Our Ref: FG/172/18/PL

**Town & Country Planning Act 1990 (as amended)
Town and Country Planning (Development Management Procedure) (England) Order 2015
Application for Full Planning Permission**

Development Change 1 No. window to bi-fold doors
Location Ocean Parade, Flat 9 Ferringham Lane Ferring

Title:
PROPOSED BIFOLD DOORS

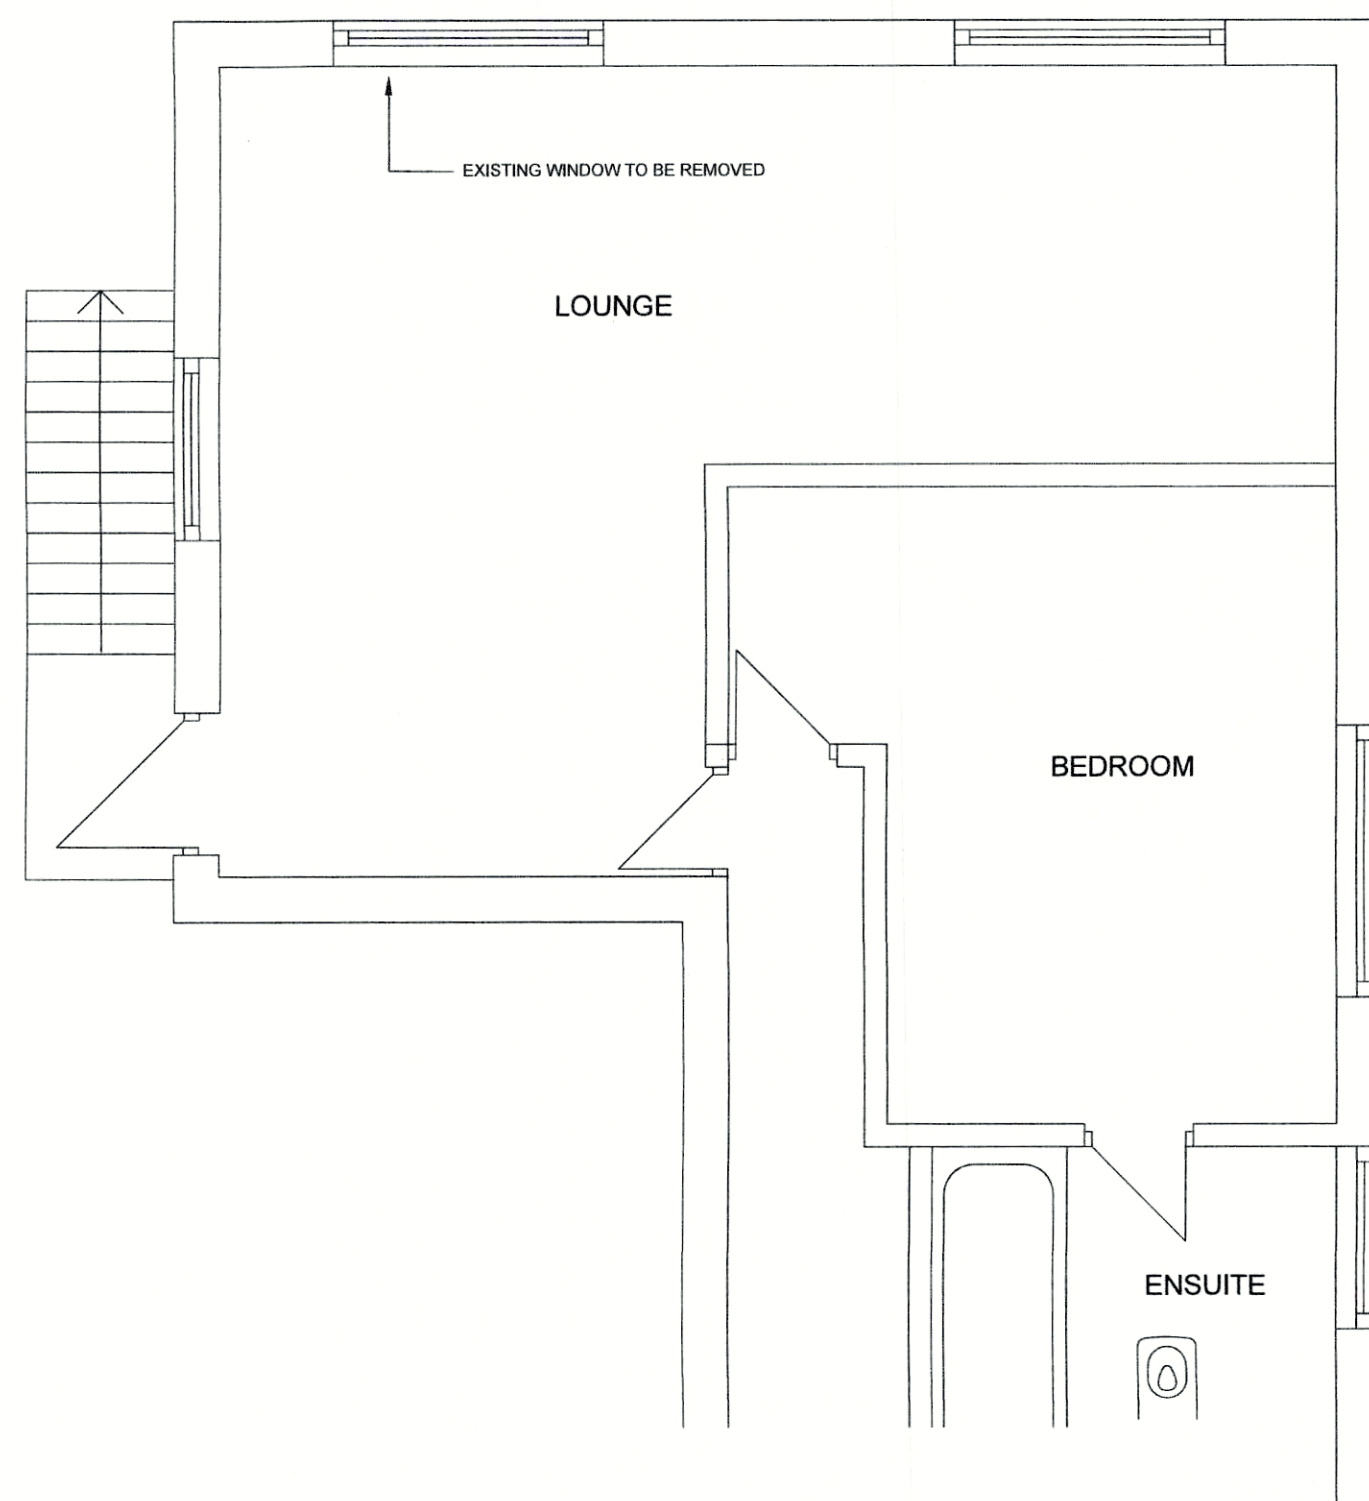
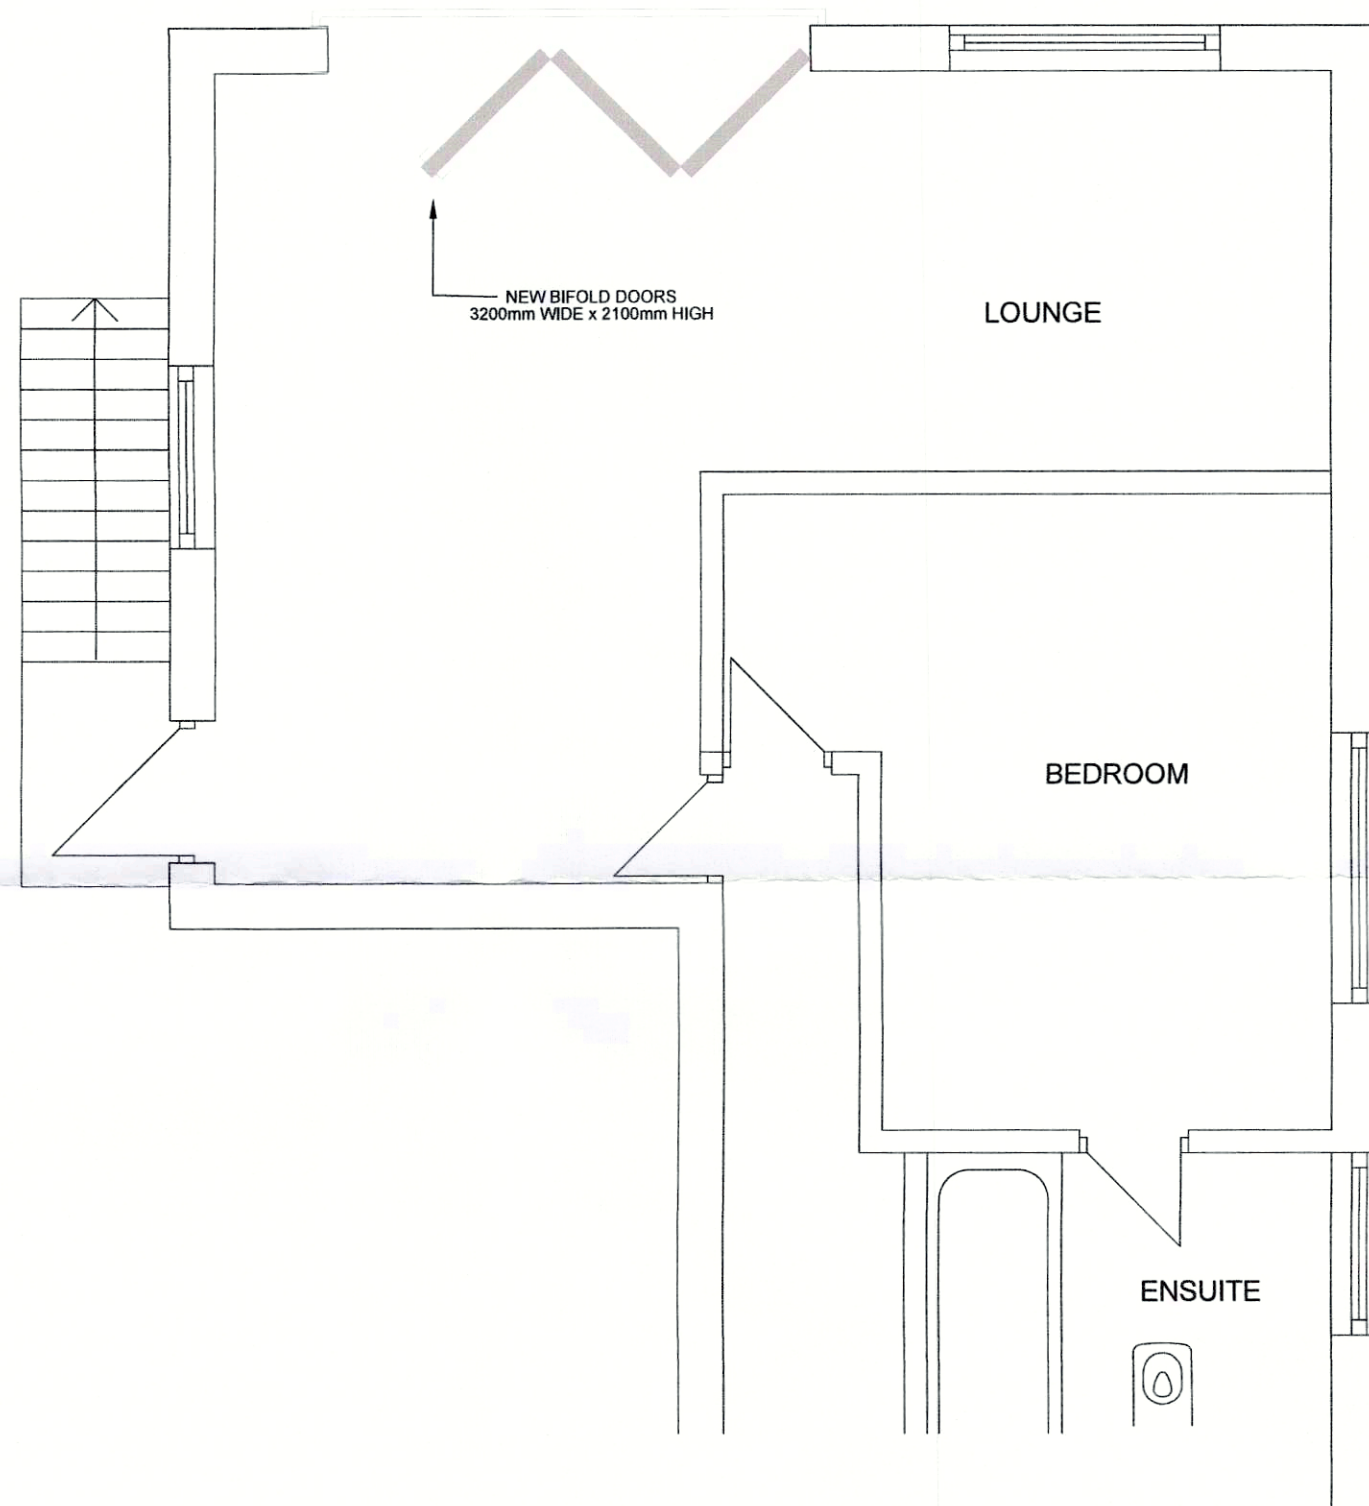
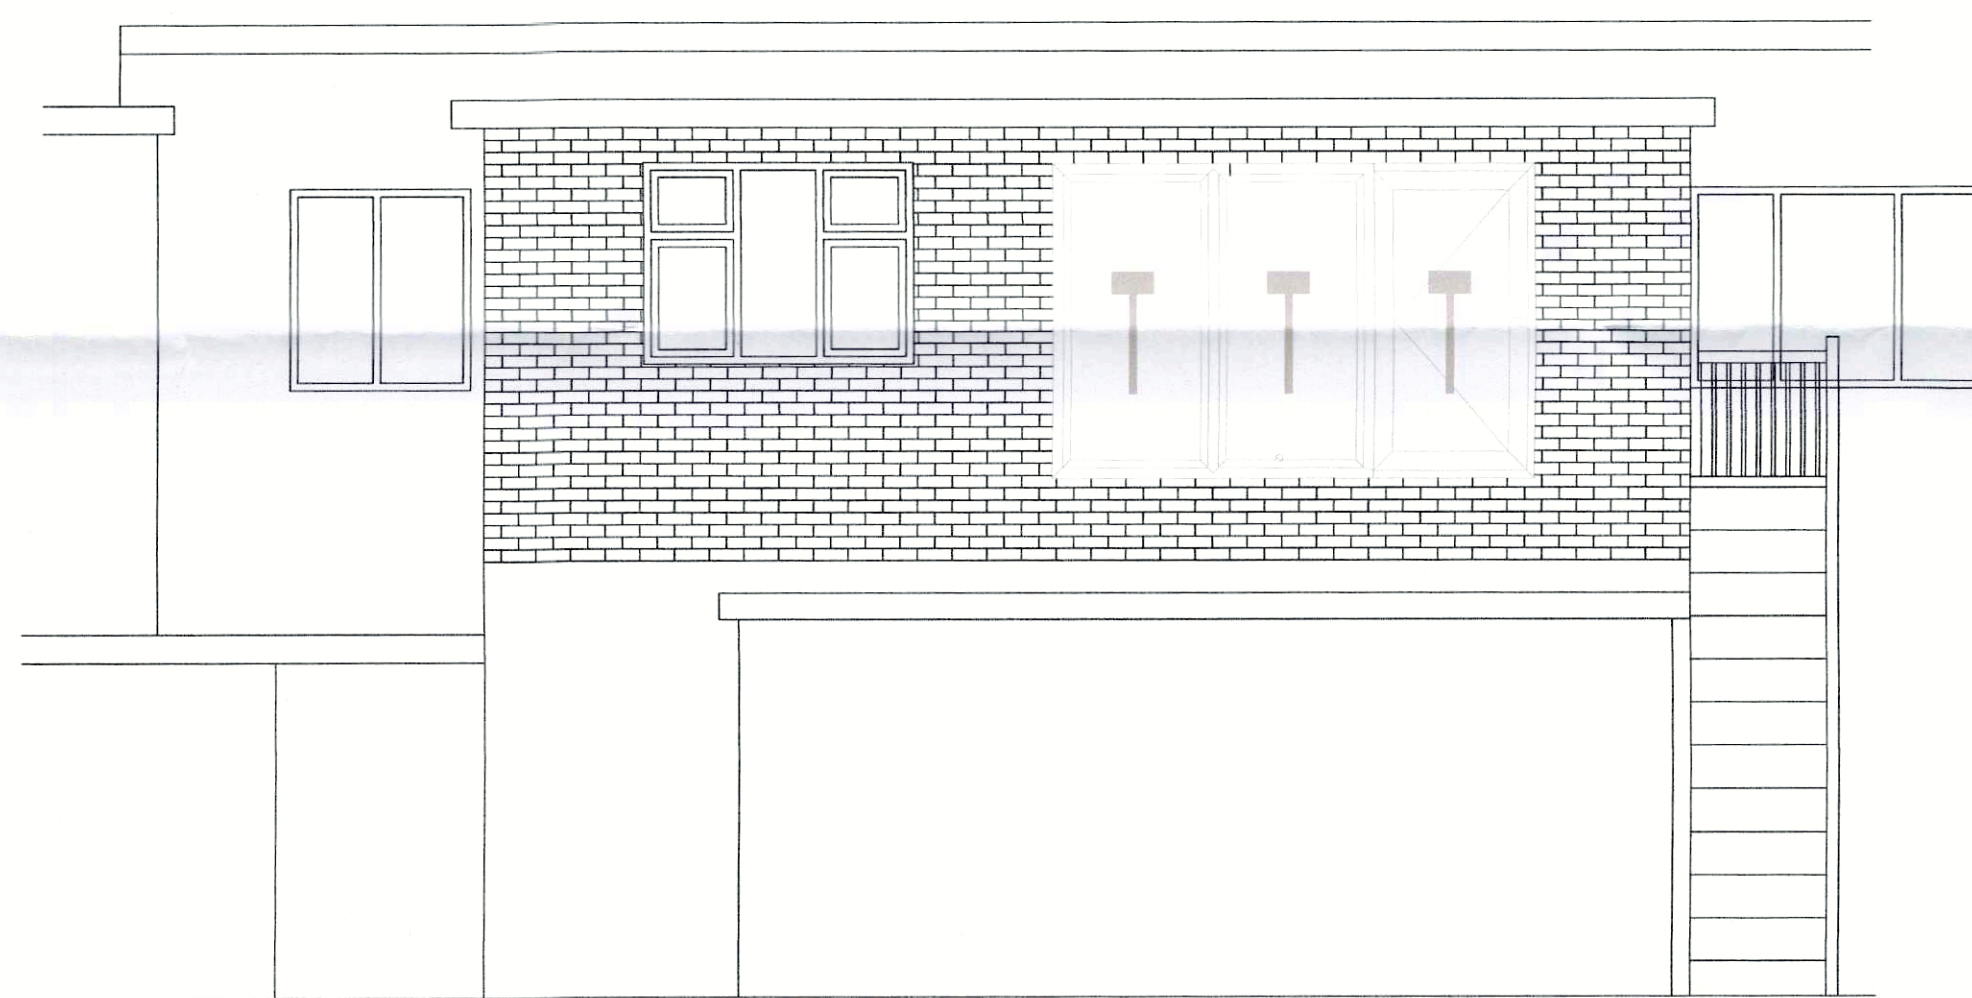
Please provide existing and proposed floor plans and elevations, all to scale correctly with each other. The floor plans and elevations need to scale correctly with each other and the location and block plan.

SITE PLAN SCALE 1:500

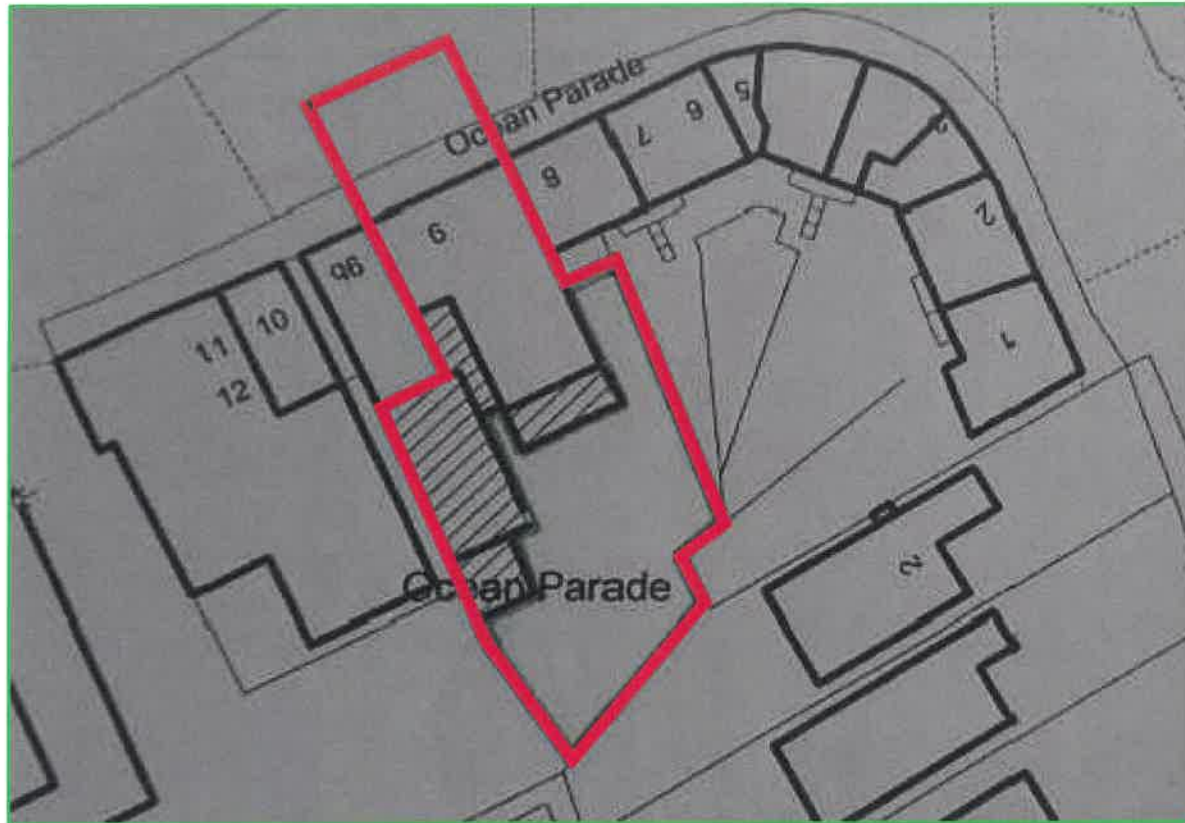
On the block plan, please highlight the proposed works.
